COMMUNITY DEVELOPMENT DEPARTMENT
80 Columbia Avenue ♦ Marysville, WA 98270 ♦ (360) 363-8100

August 19, 2022

Re: Soper Hill Station – *Technical Review 1*
PA22030

DRAWING TITLE:
LANDSCAPE PLAN

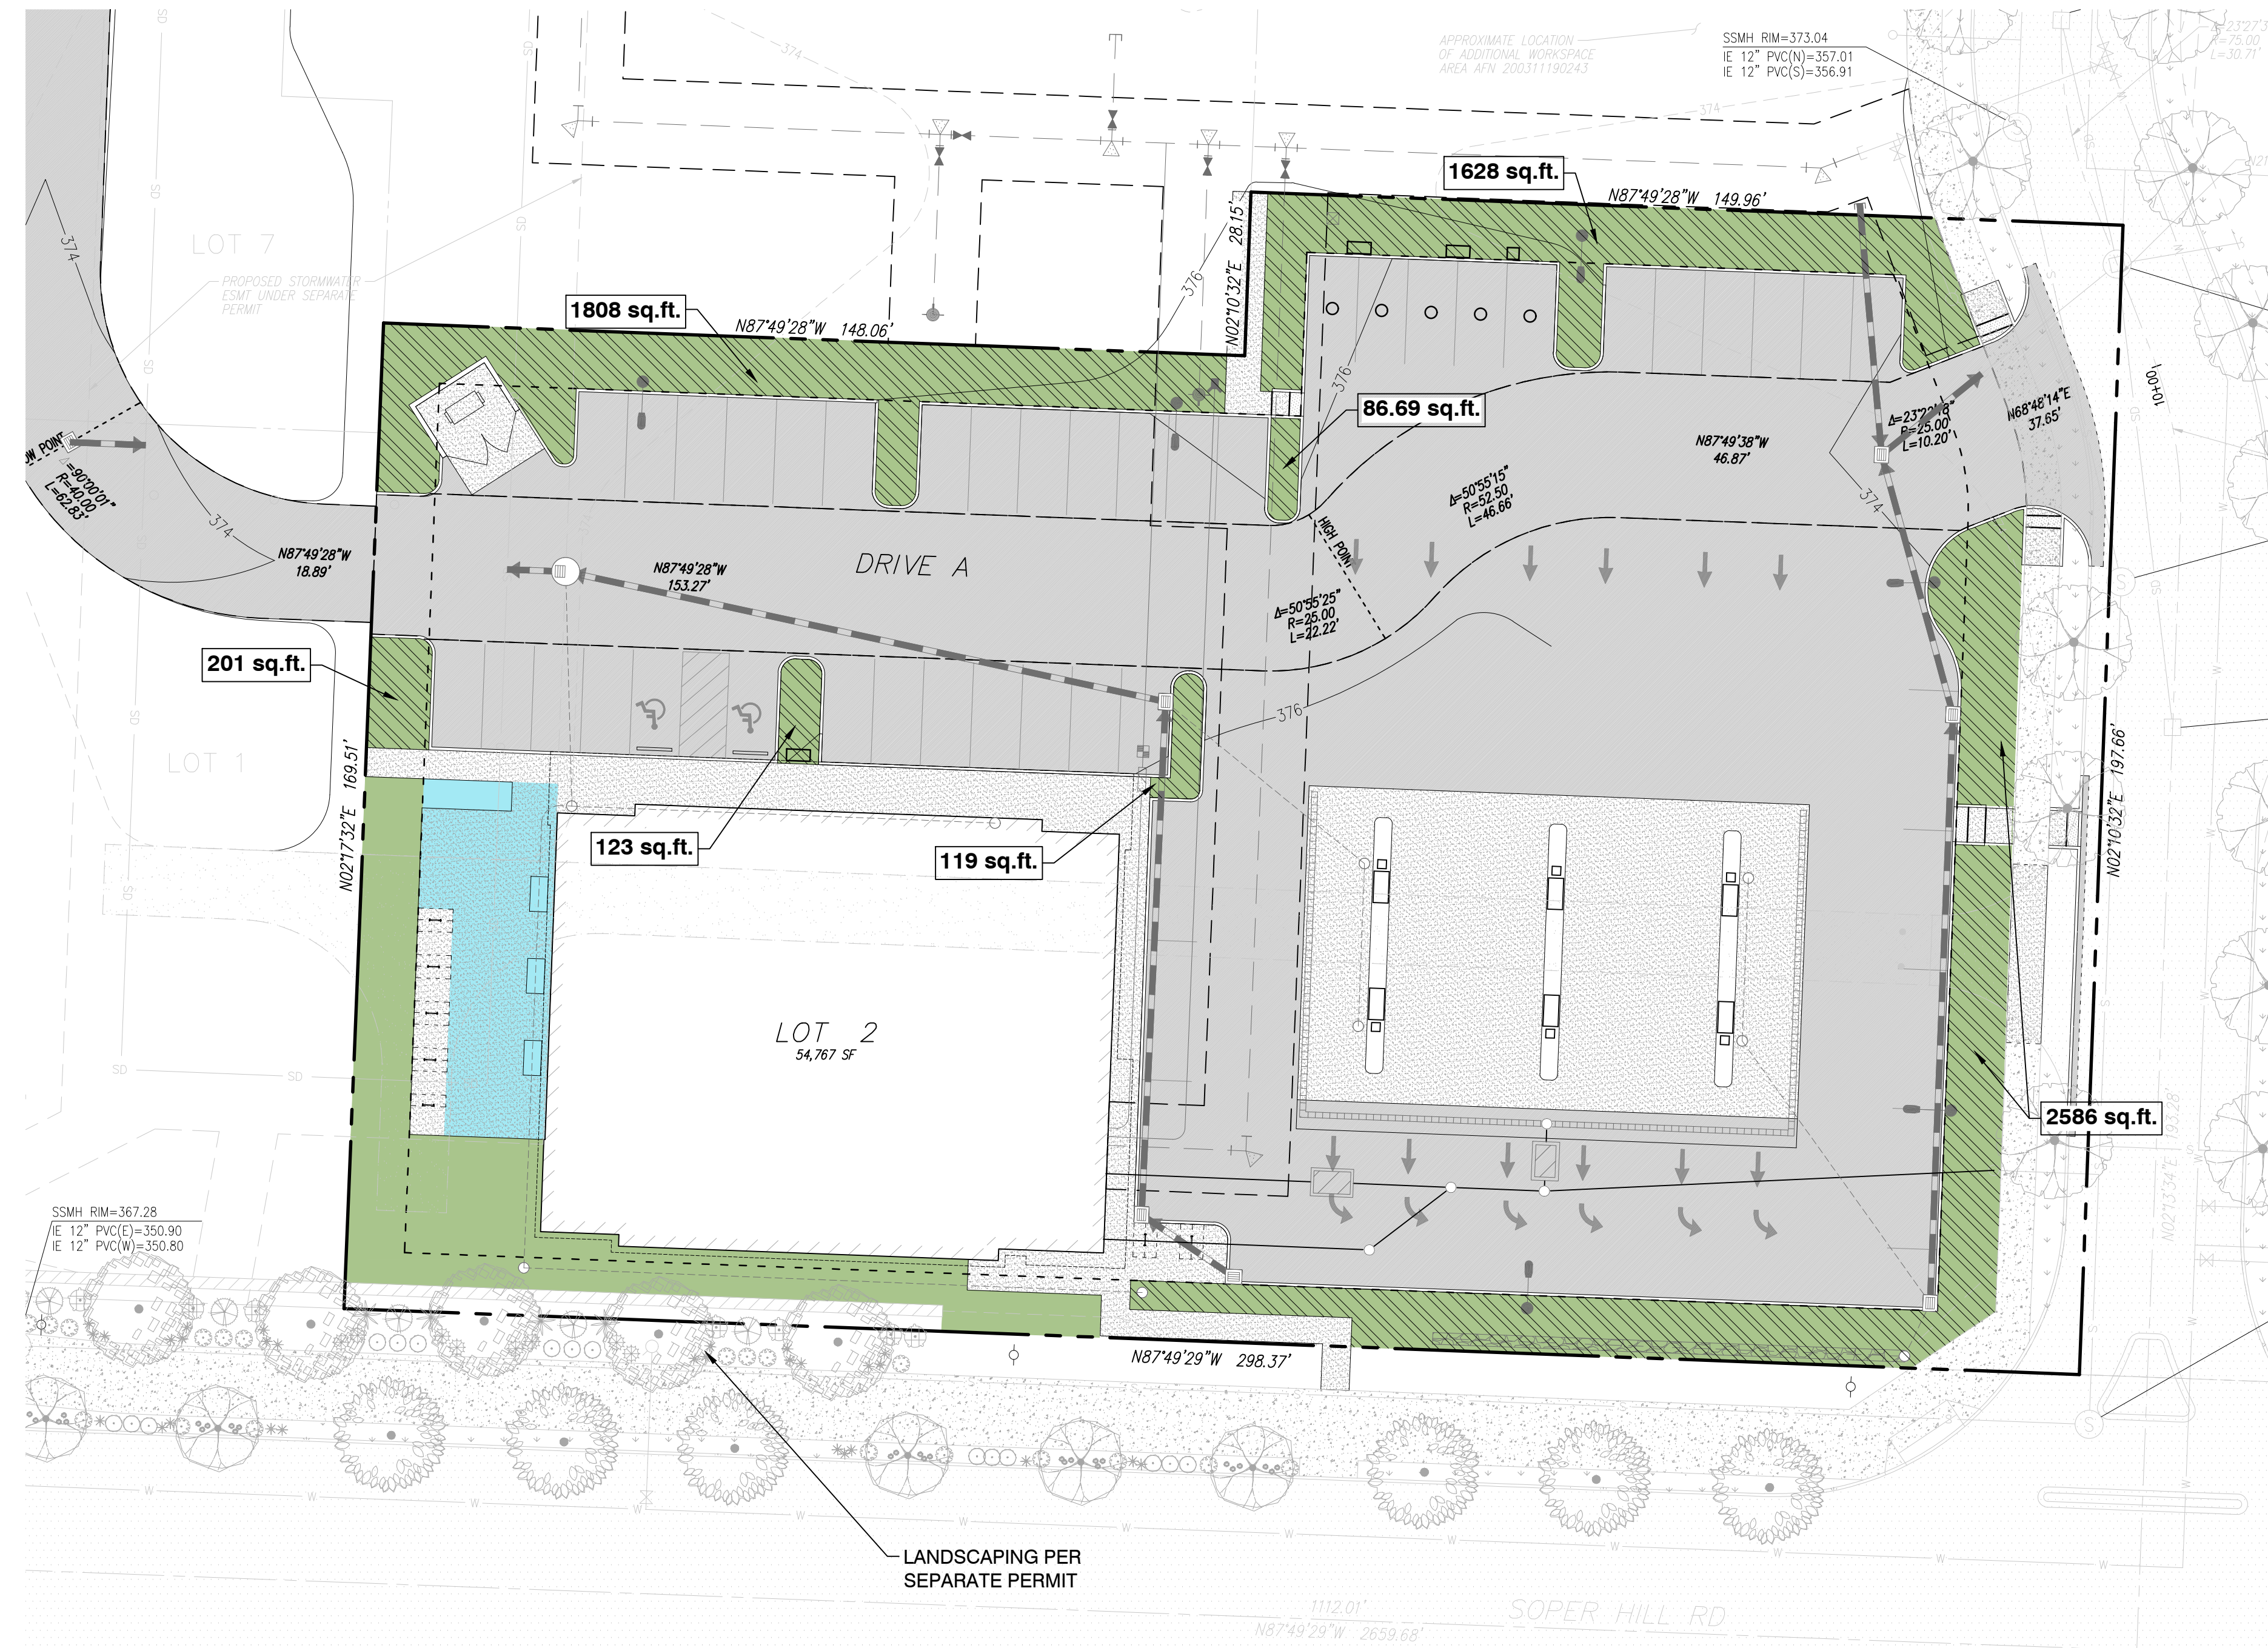
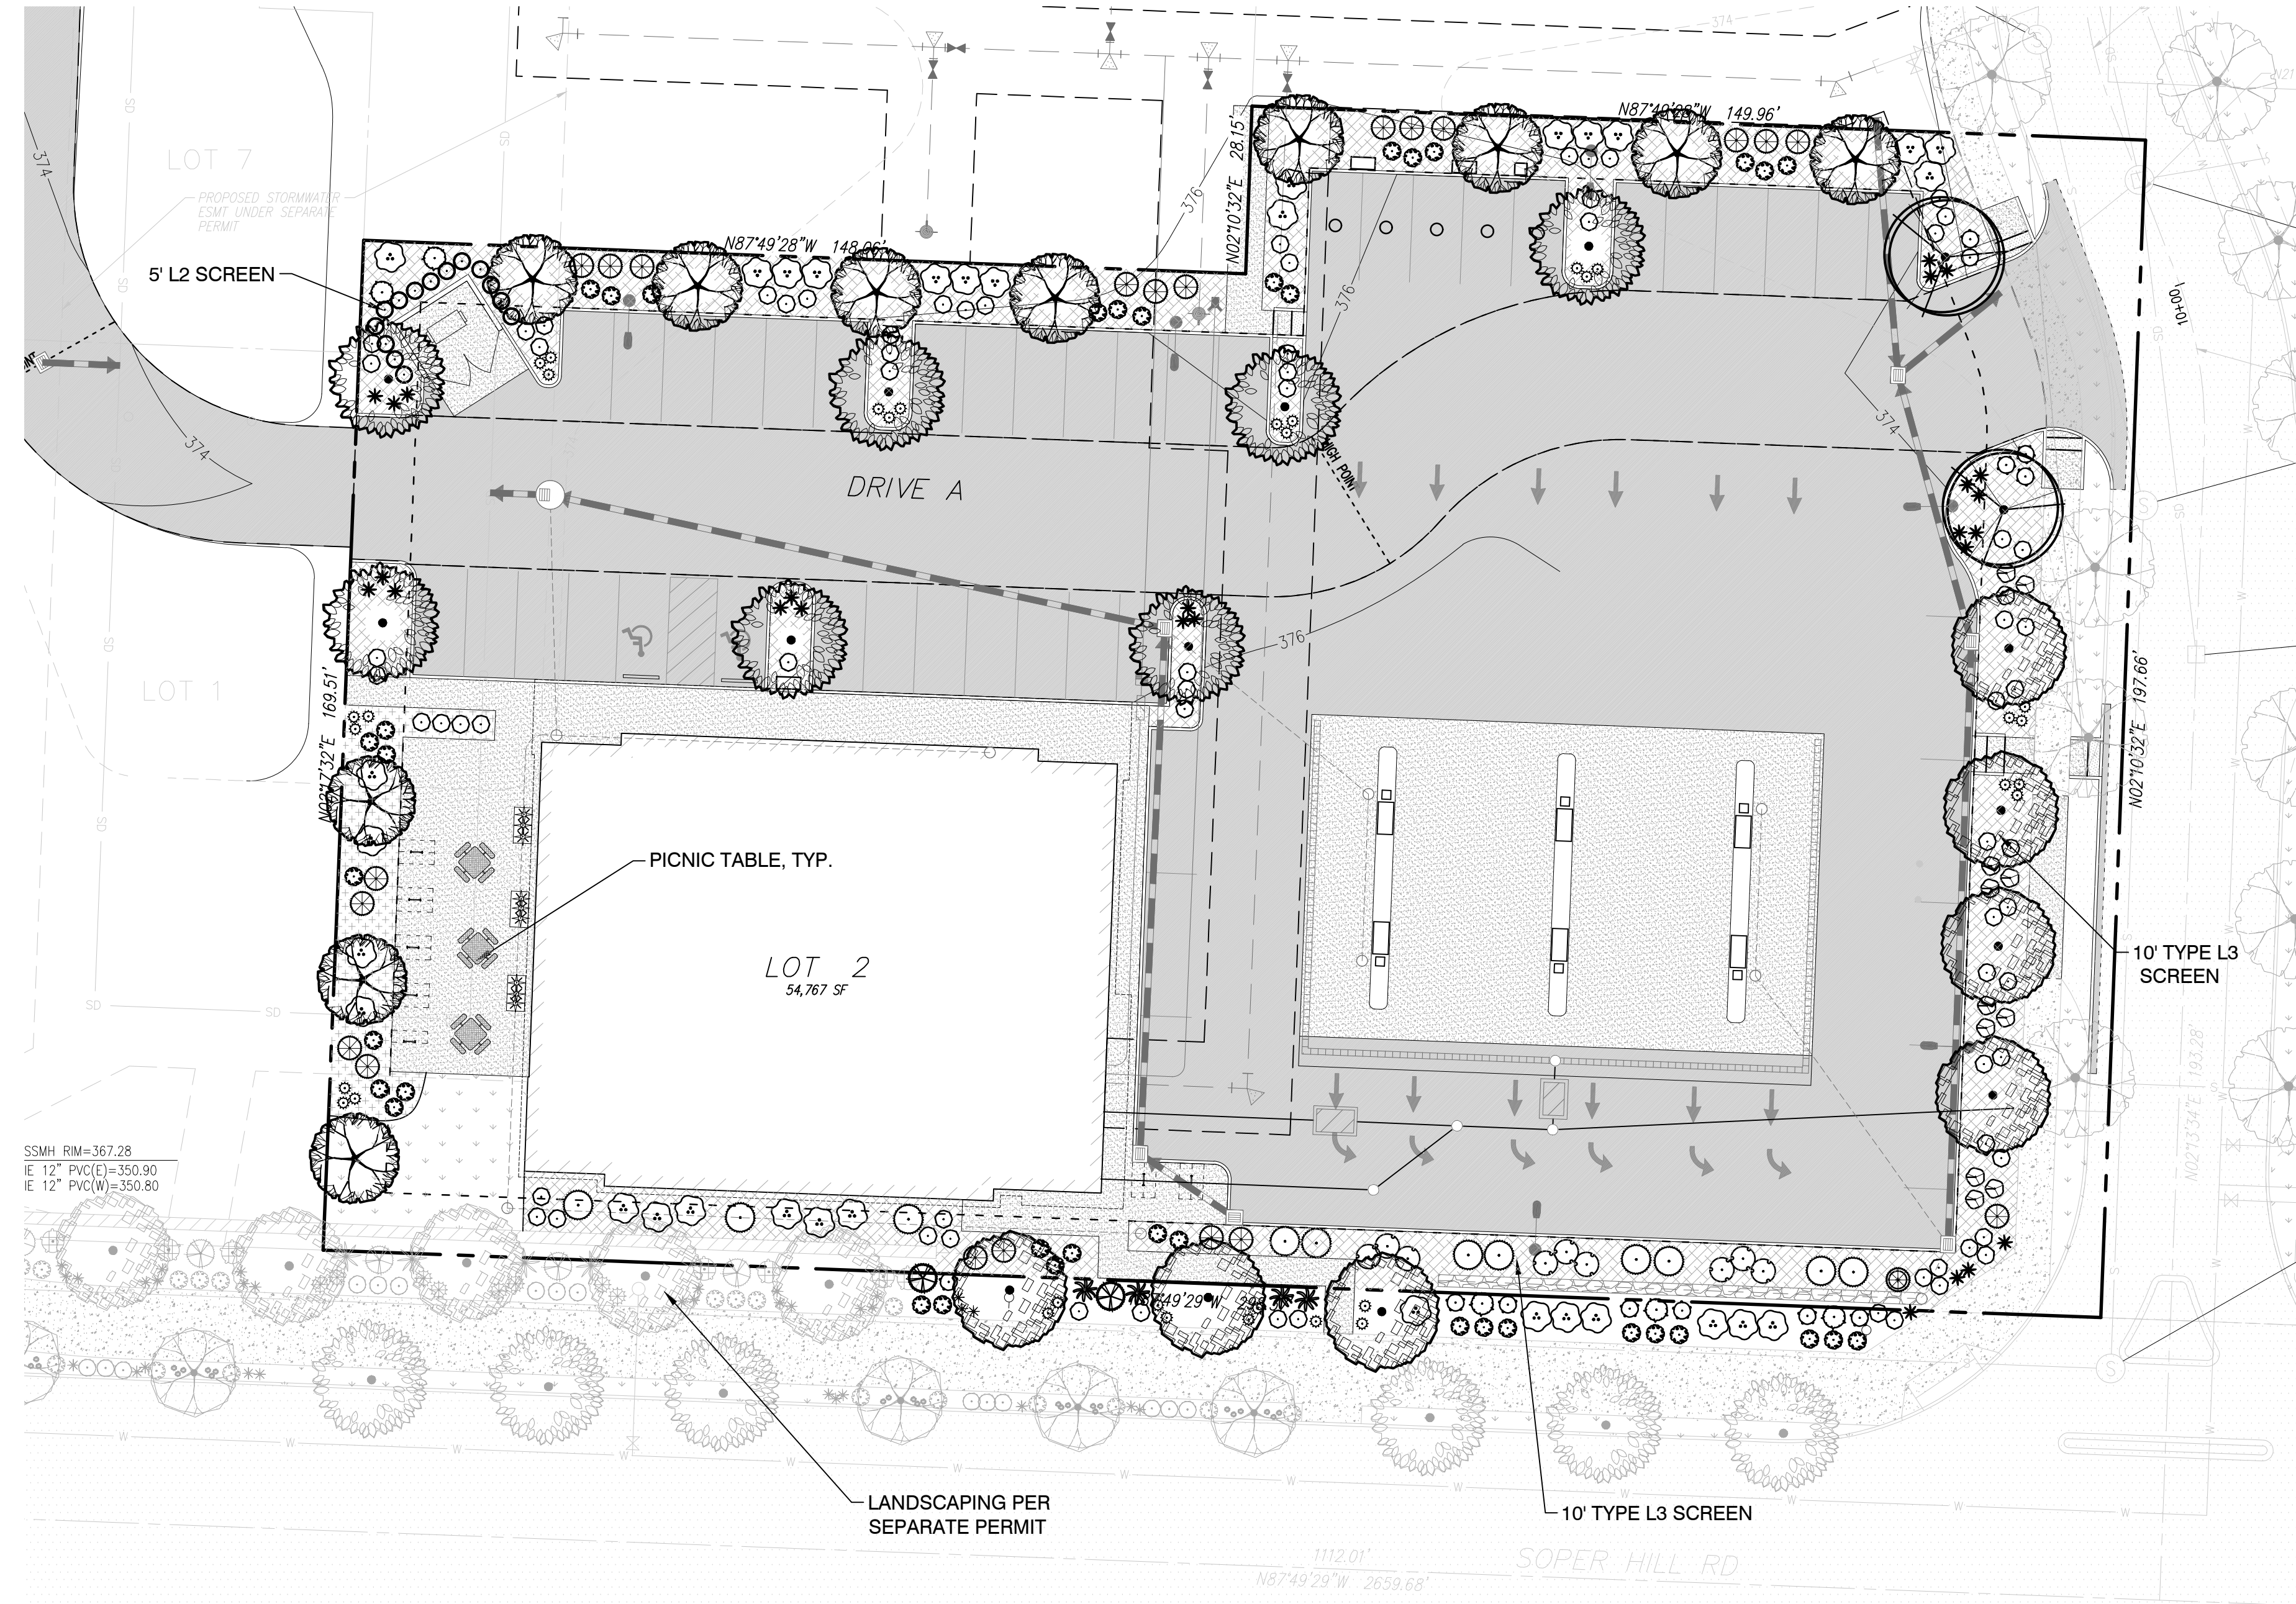
7. The following comments are related to the Landscape Plan:
- a. B.3.2.a. provide landscaping components that add seasonal interest to the space, such as plantings within pots.

- b. B.3.2.c. unscreened parking lots are prohibited adjacent to the open space. This could be accomplished by providing planting within pots on the north side of the open space.

- c. F.1.1 requires a 30' landscaping setback from Soper Hill Road and a 20' setback is required from Road A when a parking areas and drive aisles are located adjacent to these roadways.

- d. F.1.4 encourages project to use informal arrangement of plants installed in a variety of treatment that will enhance building designs, screen unwanted views, and enhance views and vistas. A formal arrangement may be acceptable if it has enough variety in layout and plants. Contiguous, long, unbroken, straight rows of a single plan should be avoided where possible.

- e. F.2.4.d.(1) requires the sides and rear of the solid waste enclosure to be screened with L1, L2, L3 or L4 landscaping at least 5' in depth.
- f. A minimum 5' L4 landscape buffer is required at the end of the row of parking on the northeast portion of the parking area.

- g. Recommend incorporating a variety of plantings with season colors within the 10' landscape buffer along the western property line adjacent to the open space, rather than lawn grass.
